**WEST SUSSEX COUNTY COUNCIL
STRATEGIC PLANNING CONSULTATION**

SUBJECT: Y/66/15/DOC

Application for approval of matters reserved by conditions imposed under Y/48/11 relating to condition No. 9, 11, 12 & 13 - details of access from site to public highway, car parking spaces, secure cycle parking & details of the proposed surface & foul water drainage.

The Lamb Inn, Bilsham Road, Yapton, West Sussex, BN18 0JN

17066-2001 D

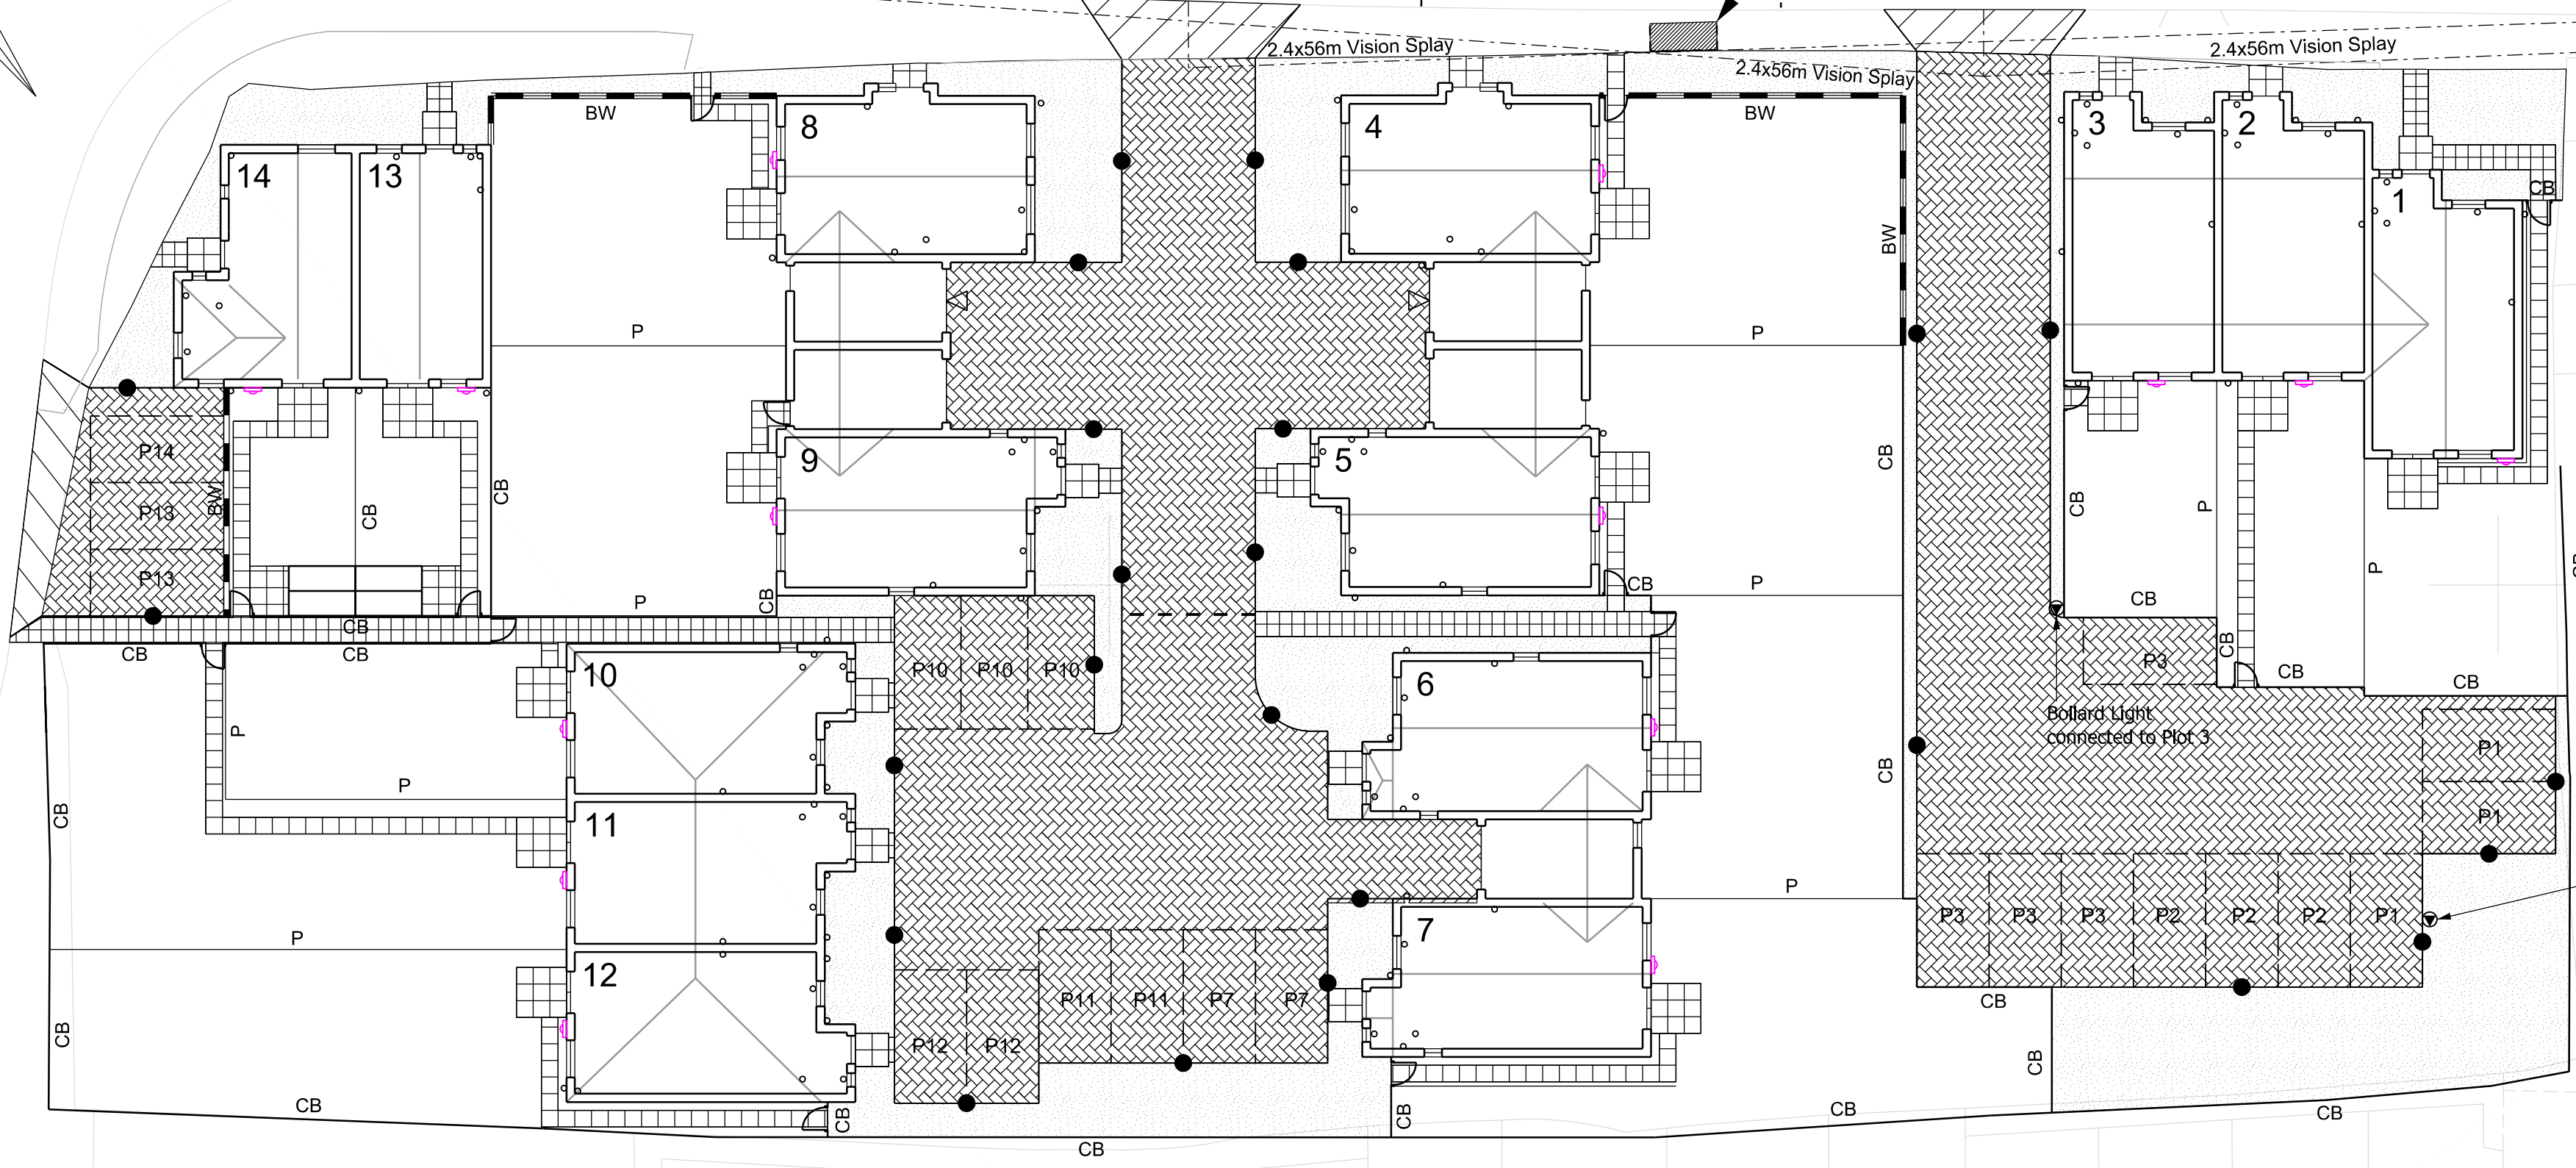
Condition 12 – cycle parking has been provided in a mixture of 2.4mx1.8m sheds and ABUS wall anchors. It is unclear as to whether the ABUS cycle parking is to be sheltered, however, it is noted that the condition only requires secure cycle parking to be provided. Therefore, the details submitted satisfy the condition but the LHA would recommend that shelter is provided for the ABUS parking as it will encourage greater use by residents and provide greater protection of bicycles from degradation caused by exposure to adverse weather conditions

Title **Bilsham Road YAPTON**
Details **S278 HIGHWAY WORKS**
Scale: 1:200 @ A1 Date: Drawn: SJT Chk: CSB
15-17 Goldington Road Bedford MK40 3NH United Kingdom T. +44 (0)1234 268862 F. +44 (0)1234 353034 mail@woodsardwick.com www.woodsardwick.com

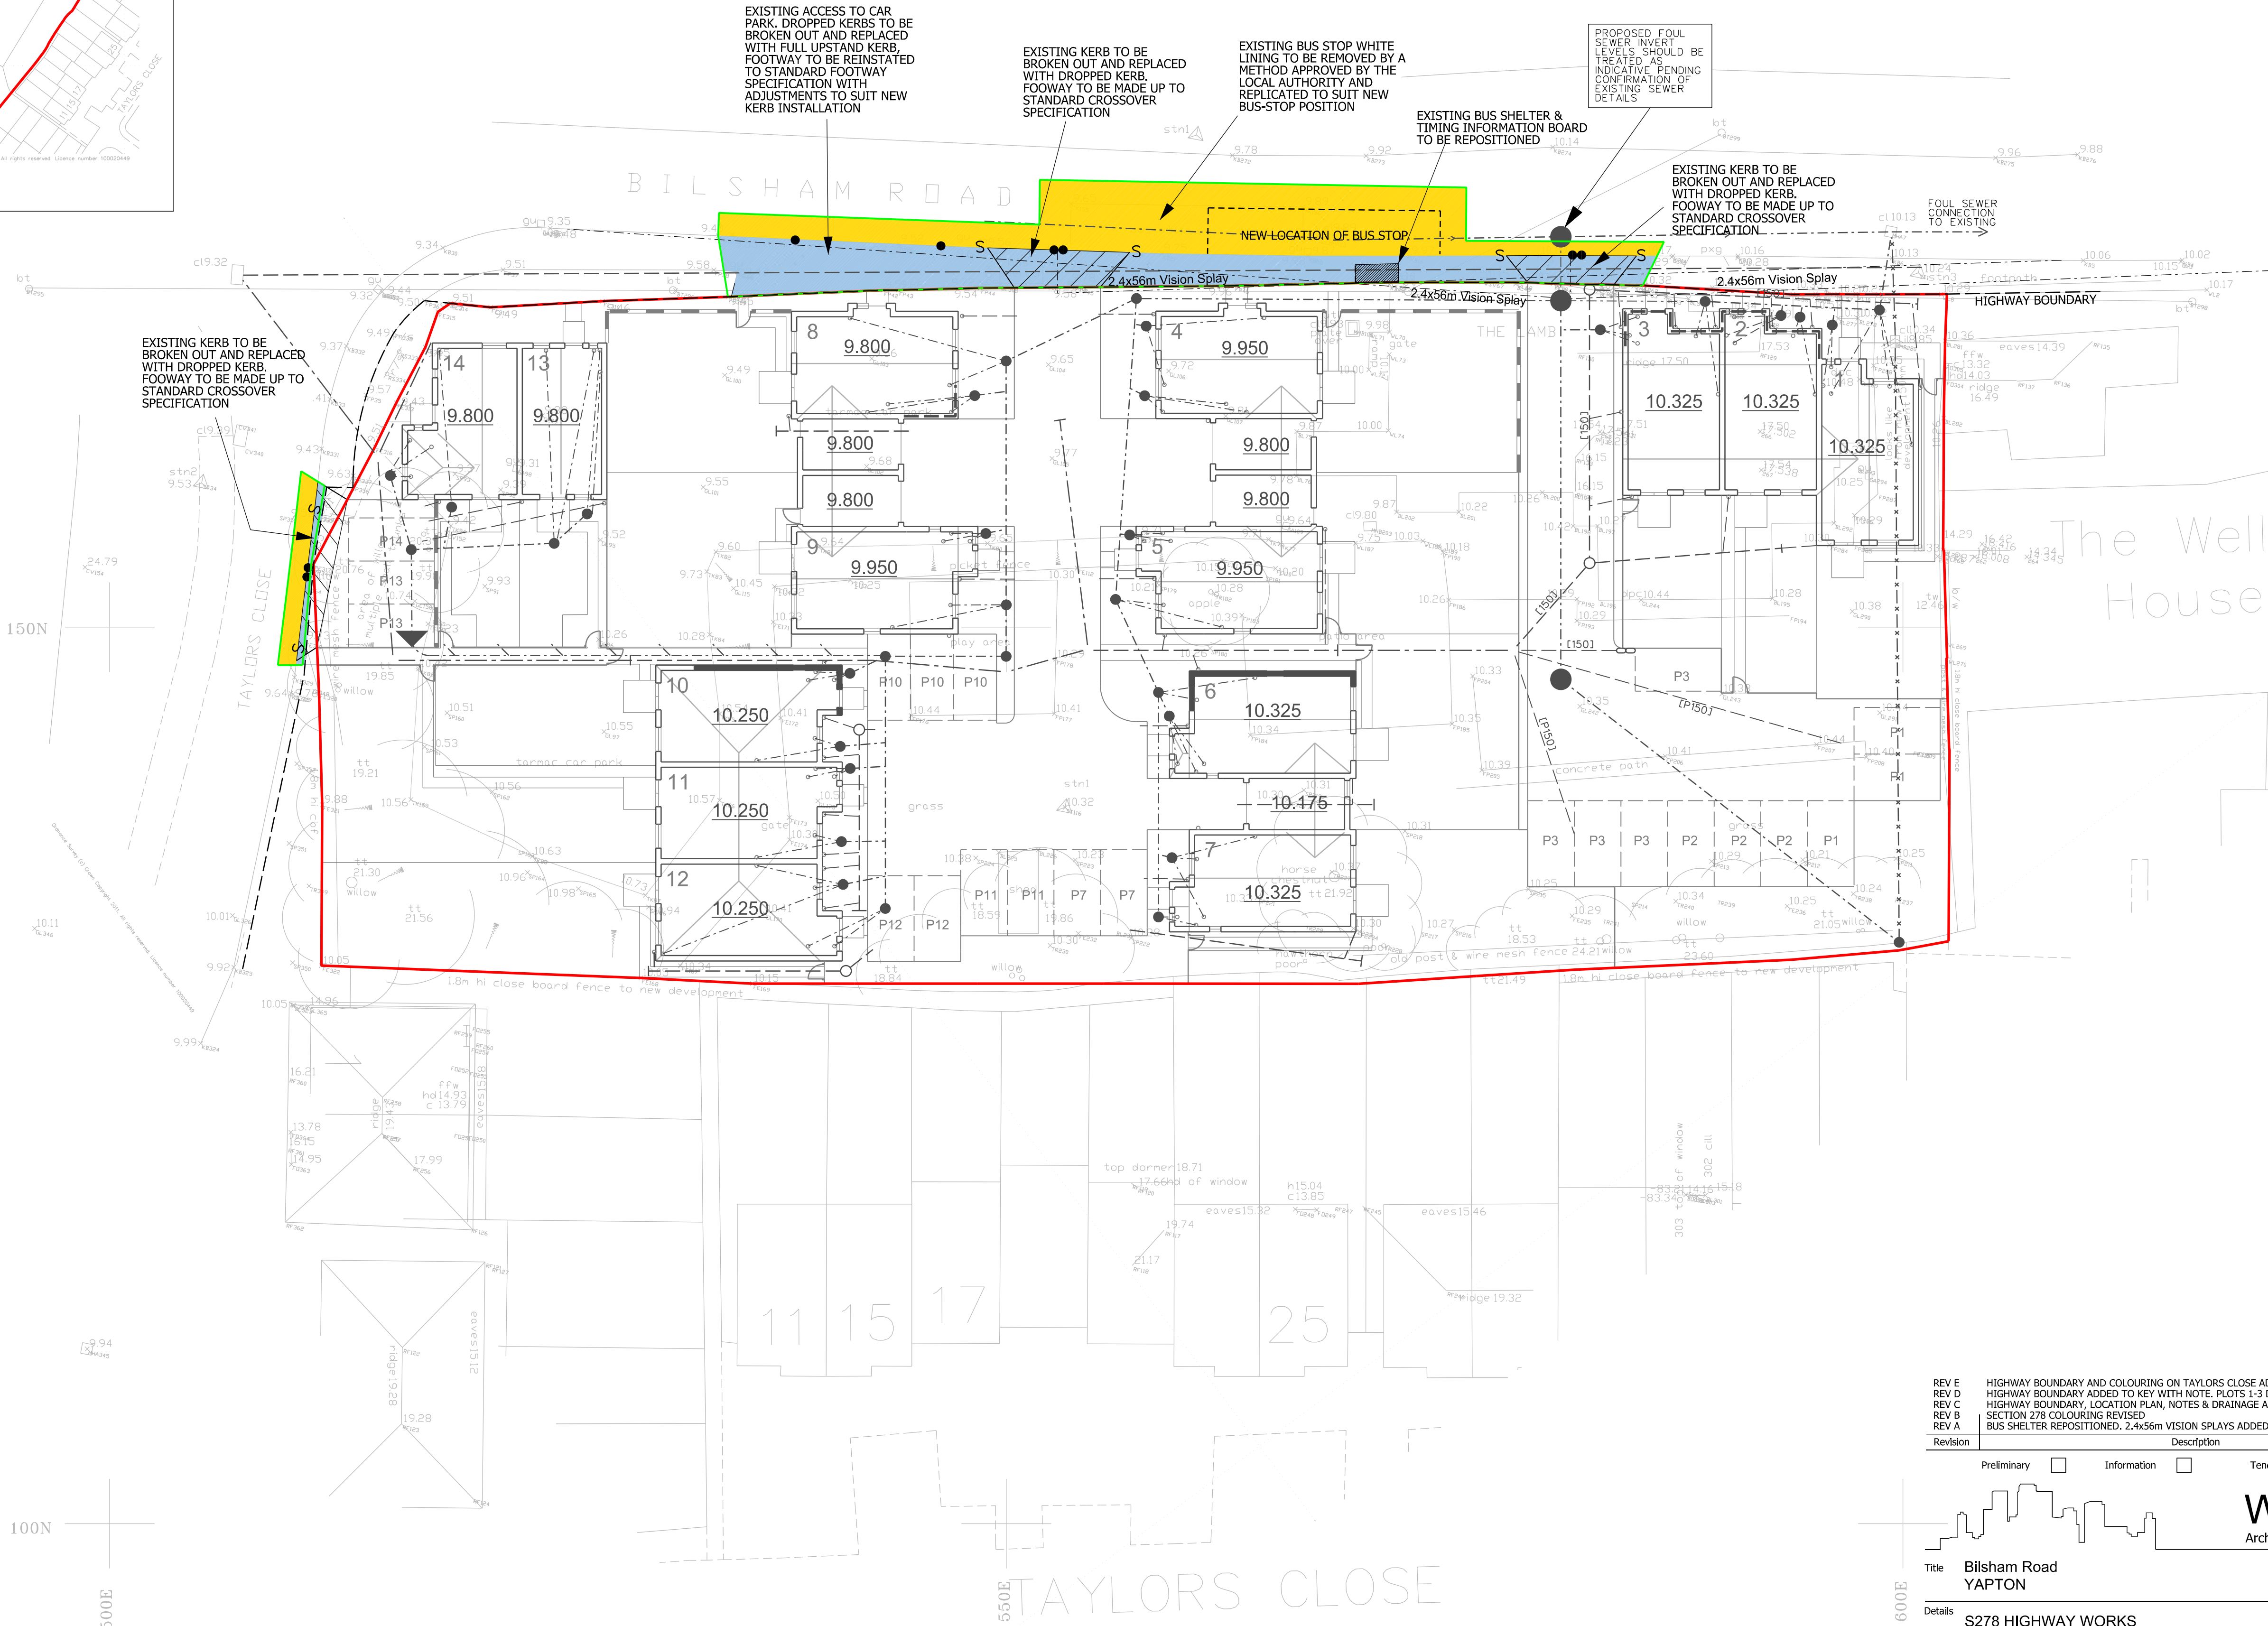
Condition 9 - technical approval has been granted through the Section 278 process. The LHA are satisfied for the condition to be discharged.
